Town & Country Planning Act 1990 (as amended)
Town and Country Planning (Development Management Procedure) (England) Order 2015
Approval of details reserved by condition imposed under FG/27/18/PL relating to conditions 7-
Construction Management Plan & 10-protection of retained trees.
Ferringham House 58 Ferringham Lane, Ferring,

Arun District Council have decided to **REFUSE details reserved by condition for the following reasons:**

Drawing Title  
**Amended Tree Protection Plan**

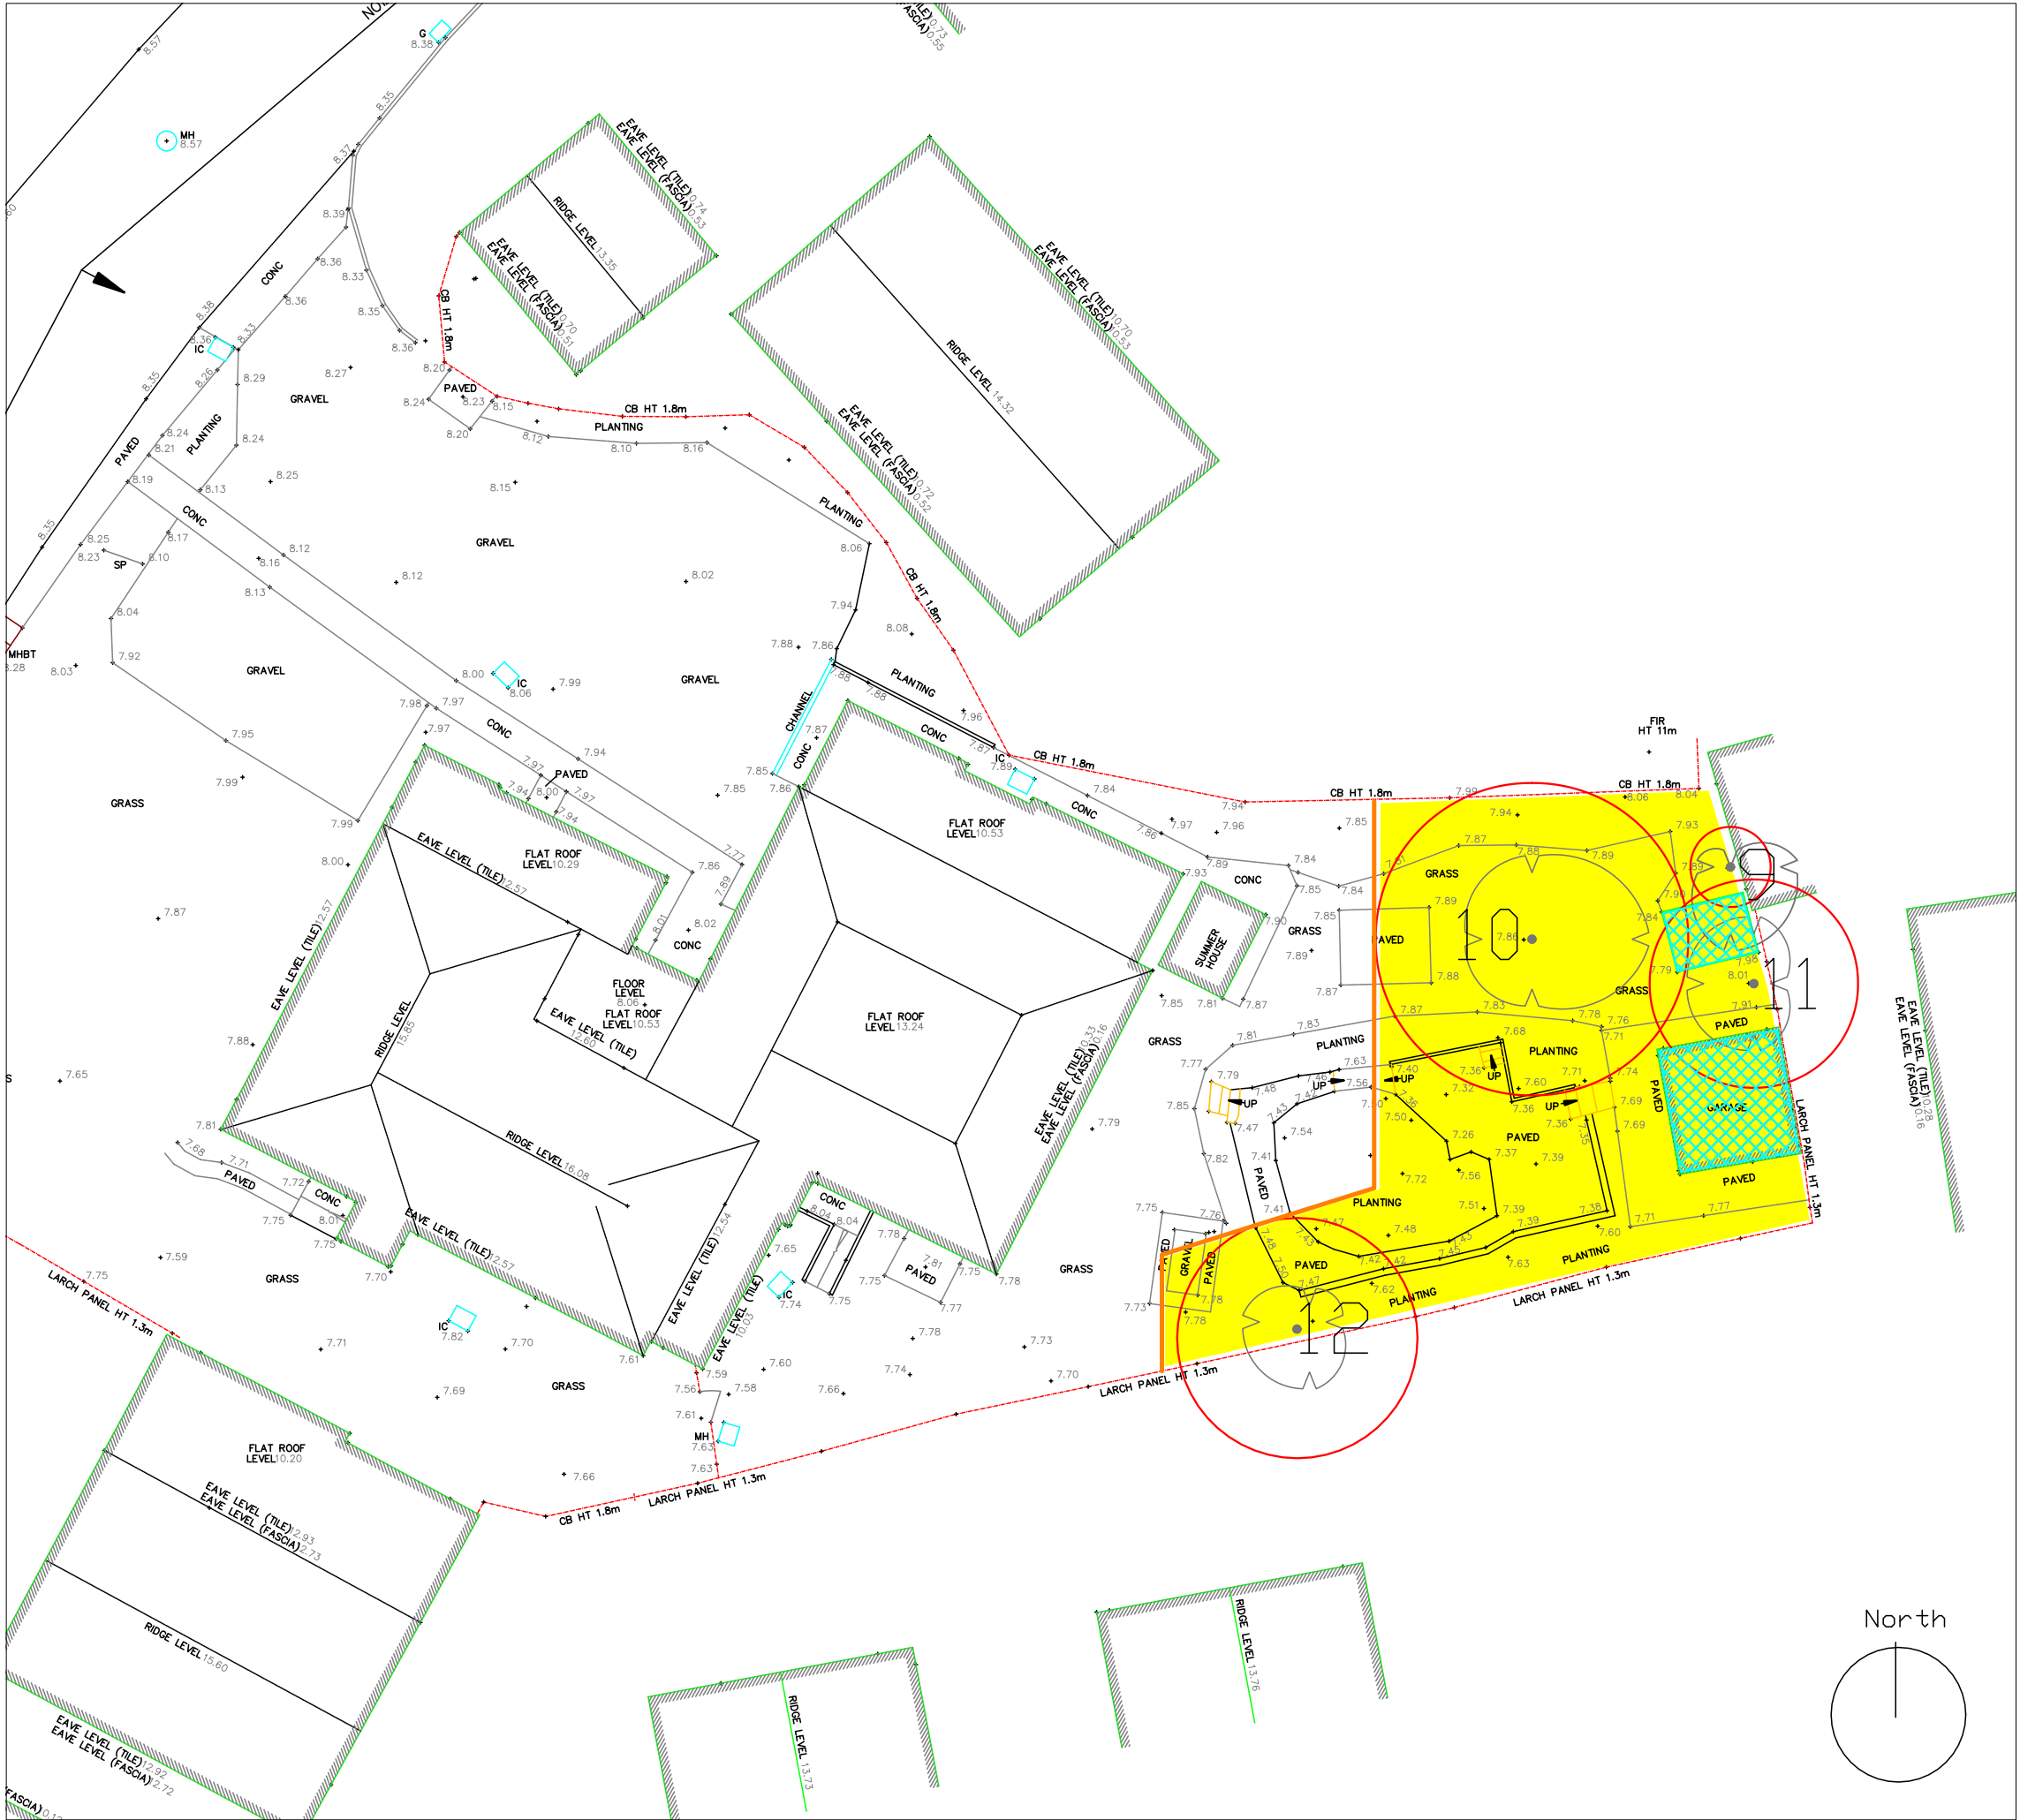
The provision (and subsequent agreement by the LPA) of a suitable Tree Protection Plan (TPP) is not of itself sufficient to discharge the condition.

Any tree protection measures must be in place before heavy plant access, soil movement, demolition or construction occurs. The prior installation of an effective 'Construction Exclusion Zone' must be inspected by and be to the satisfaction of the LPA (Tree Officer) before the relevant condition can be discharged. Anything less and potentially irreversible damage to those trees identified for retention could result.

It is recommended that fencing is installed in accordance with the Tree Protection Plan to form an effective Construction Exclusion Zone so as to adequately respect and protect significant trees before any work occurs.
